## MEMORANDUM

**TO:** Nell Donaldson, Planner  
**FROM:** David Senus, P.E. & Ashley Auger, E.I.T.  
**DATE:** September 2, 2014  
**RE:** Pamela Road Extension, Final Level II Site Plan Application

Woodard & Curran has reviewed the Final Level II Site Plan Application for the proposed extension of Pamela Road in Portland, Maine. The project involves the construction of approximately 750 feet of new road along a paper right-of-way that was established in 1969.

Drawing file: final approved plans / 33229-DETAILS STORMBASIN.pdf

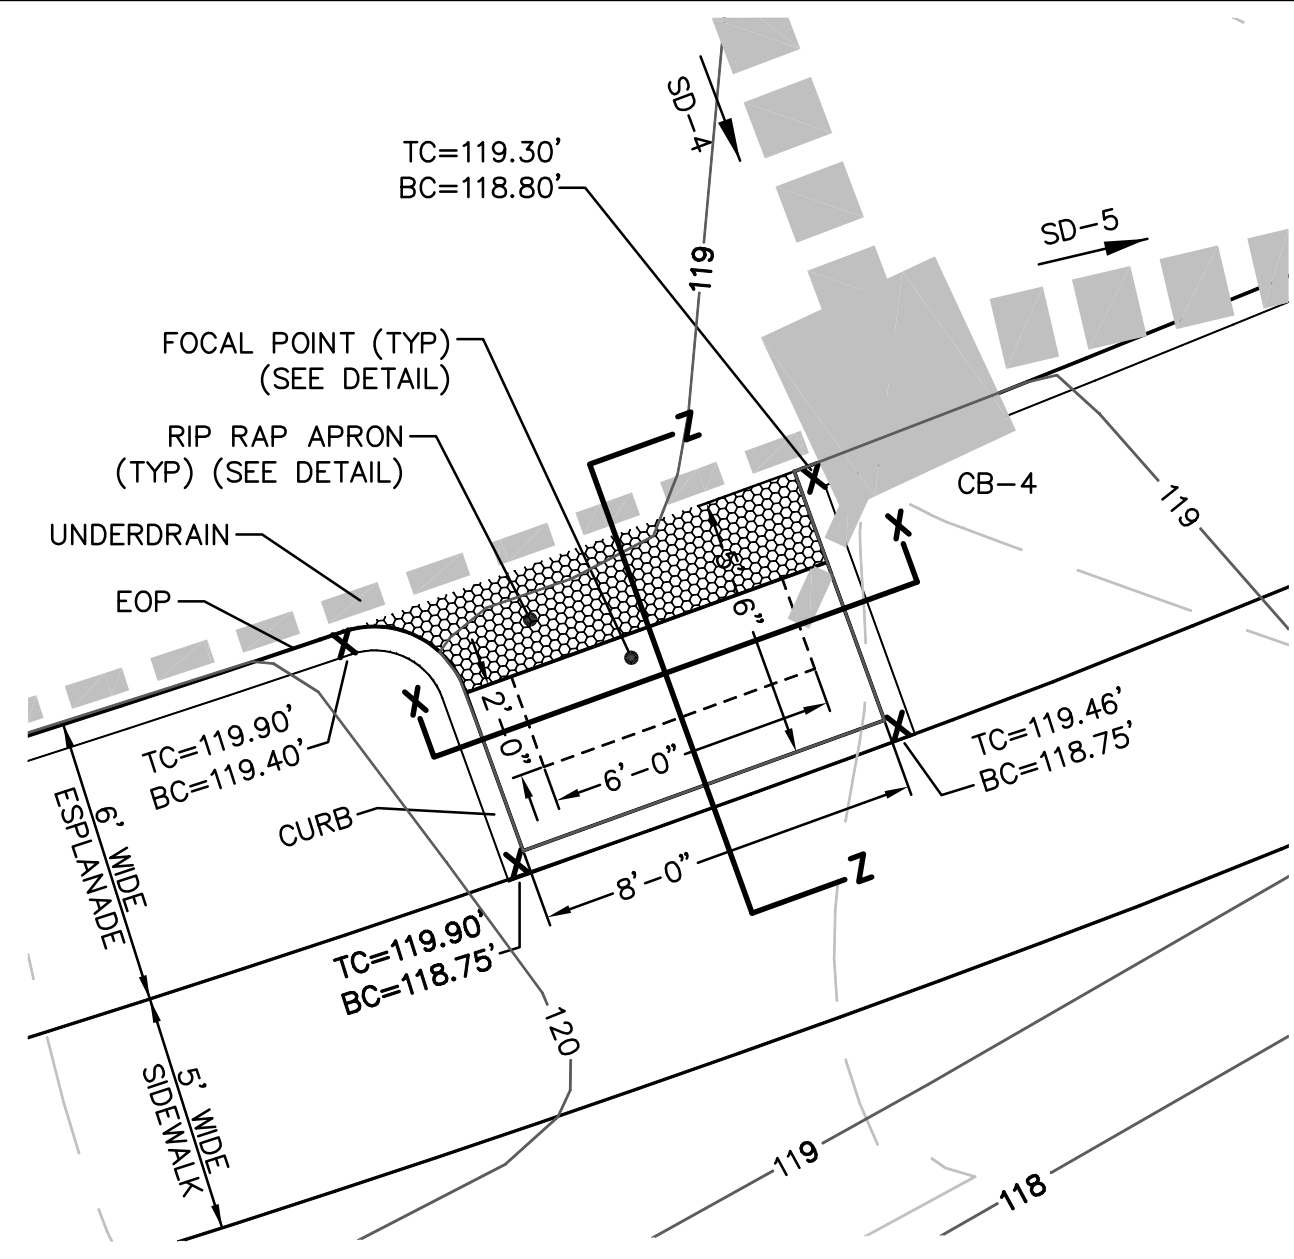
- 7) In accordance with Figure II-2 of the City of Portland Technical Manual, catch basins should have a minimum three foot sump; the proposed detail specifies two feet. The Applicant should revise accordingly.

- 8) The catch basin Frame and Grate detail on Sheet 10 of 11 does not meet City Standard; the City's standard is shown on Figure II-7 of the City of Portland Technical Manual. The detail should be revised accordingly.

Drawing Name:
GRADING & DRAINAGE PLAN

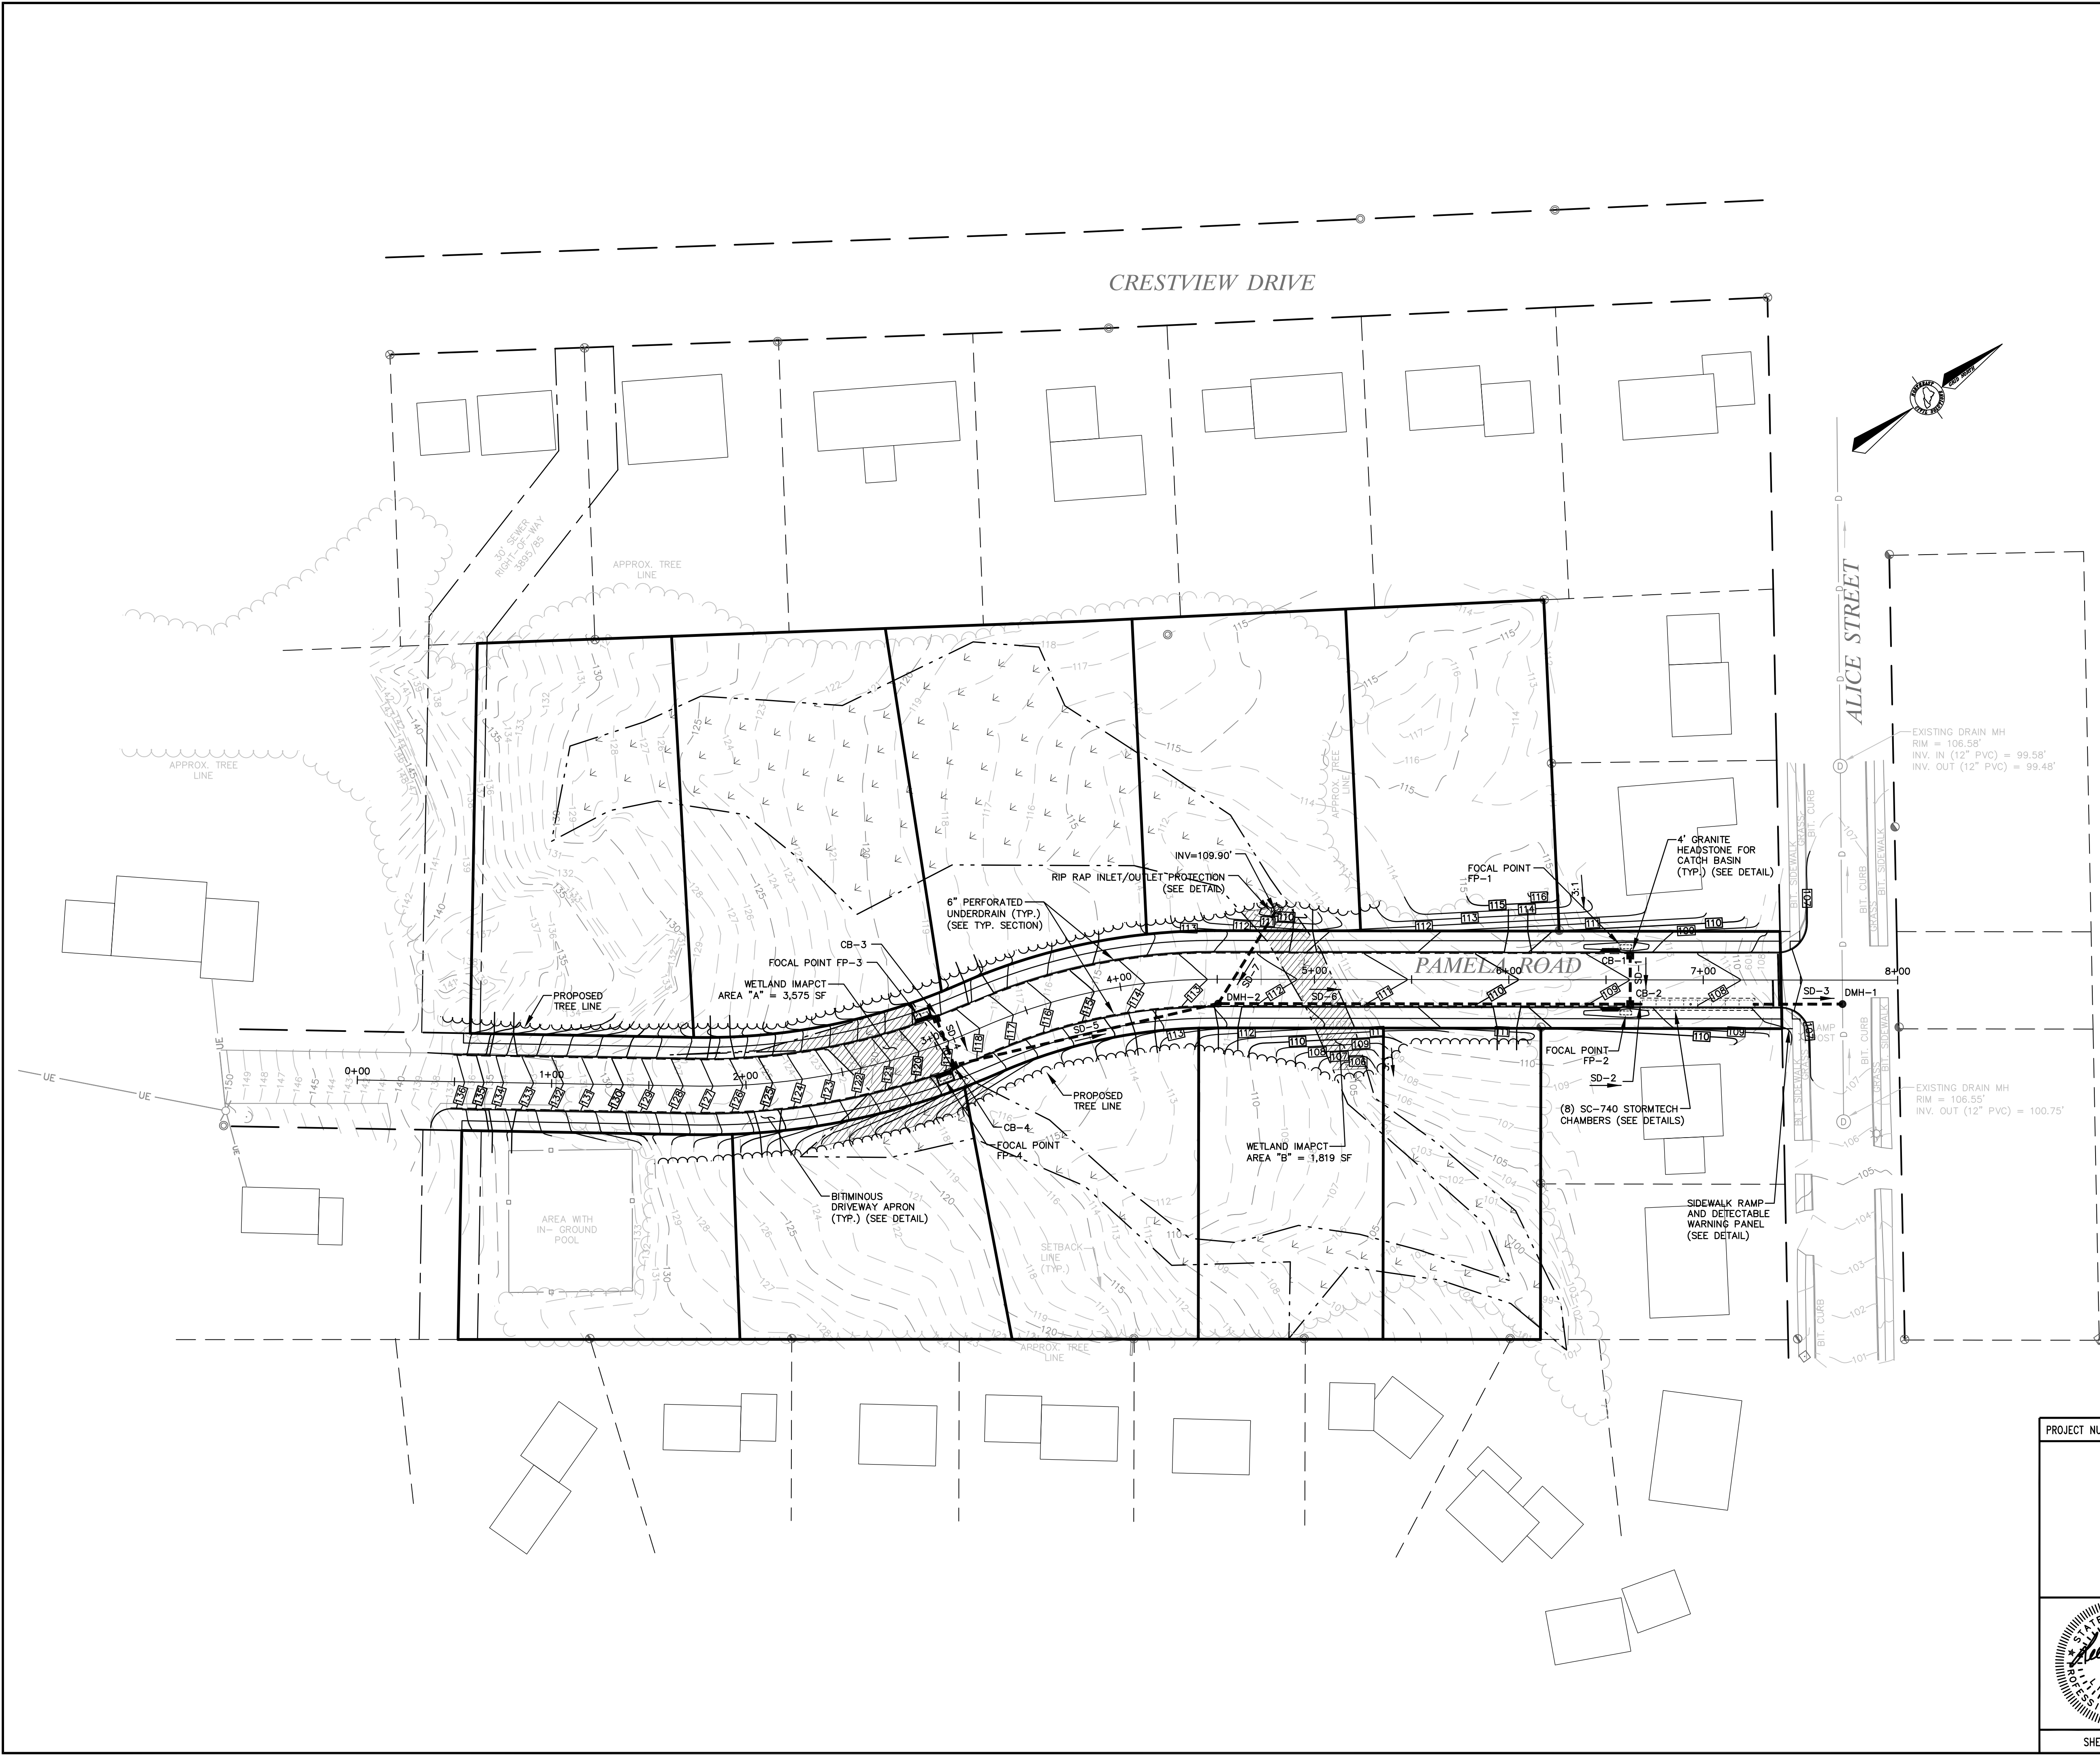
- 11) Sheet 3 of 11 includes a pipe schedule that lists pipe materials as "Corrugated HDPE (Smooth Interior)". Corrugated HDPE is not an allowable pipe in the City Right-of-Way; allowable pipes are listed in Section 2.5 of the City of Portland Technical Manual

- b) The connection pipes between the Isolator Row and the access/diversion structures should be 24-inches for the SC-740 chambers (for this case, Pipe SD-2).

INFILTRATION SYSTEM #1
SCALE: 1" = 10'

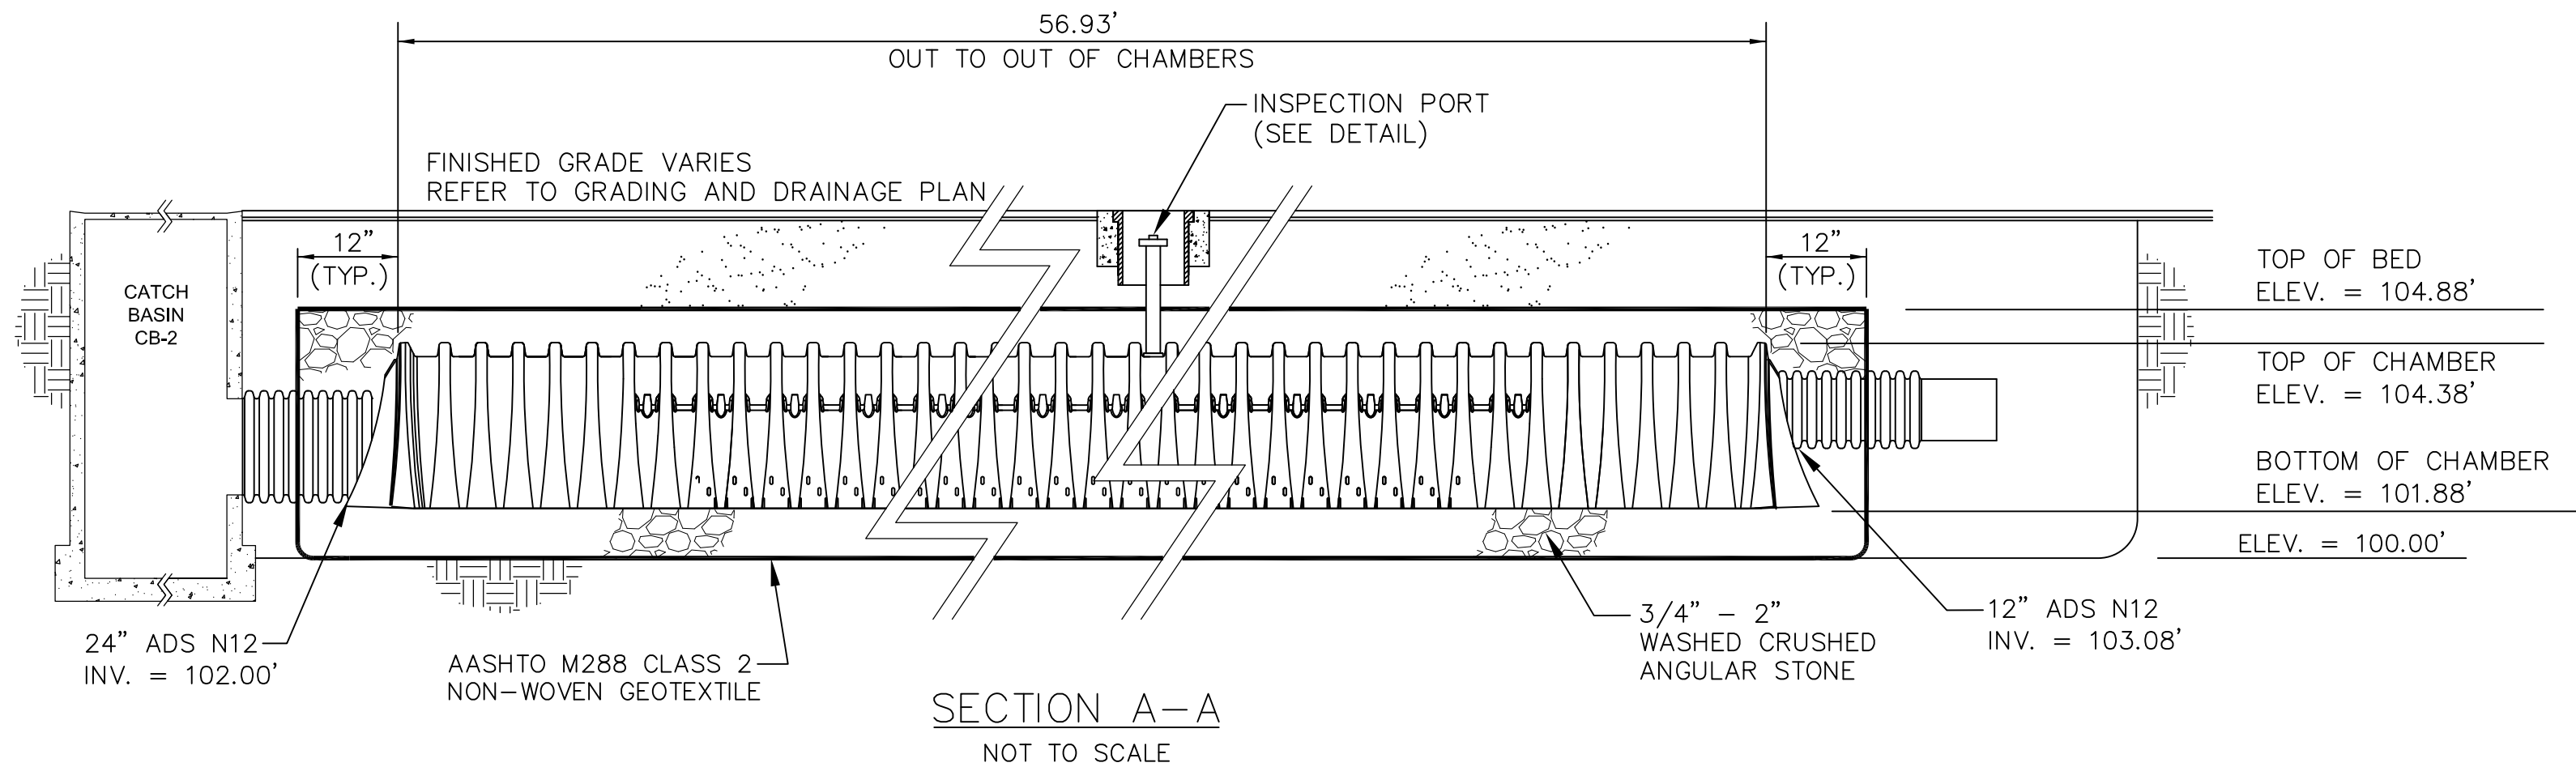
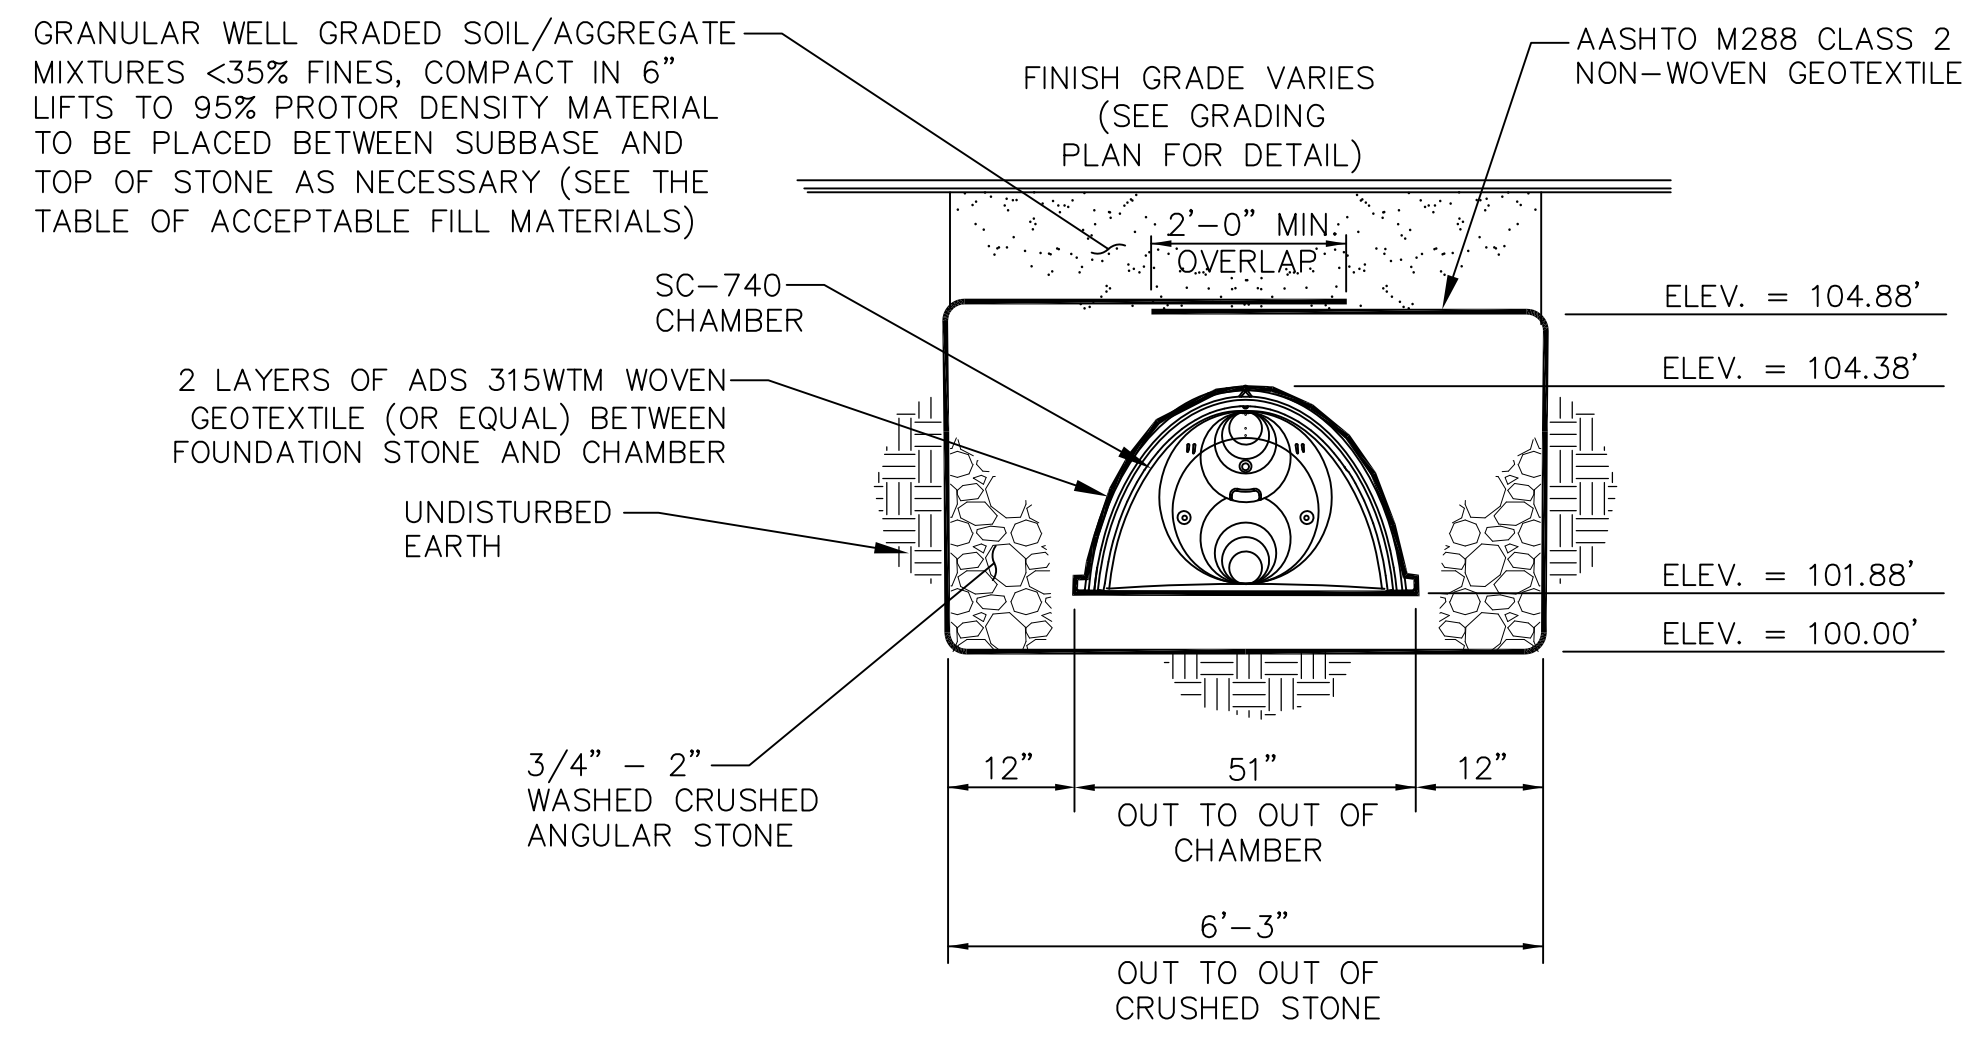
- 12) Per Chapter 7.3 of Volume III of the MaineDEP Stormwater BMP Manual:
  - a) Two layers of woven geotextile fabric shall be placed between the stone and the Isolator Row chambers; and
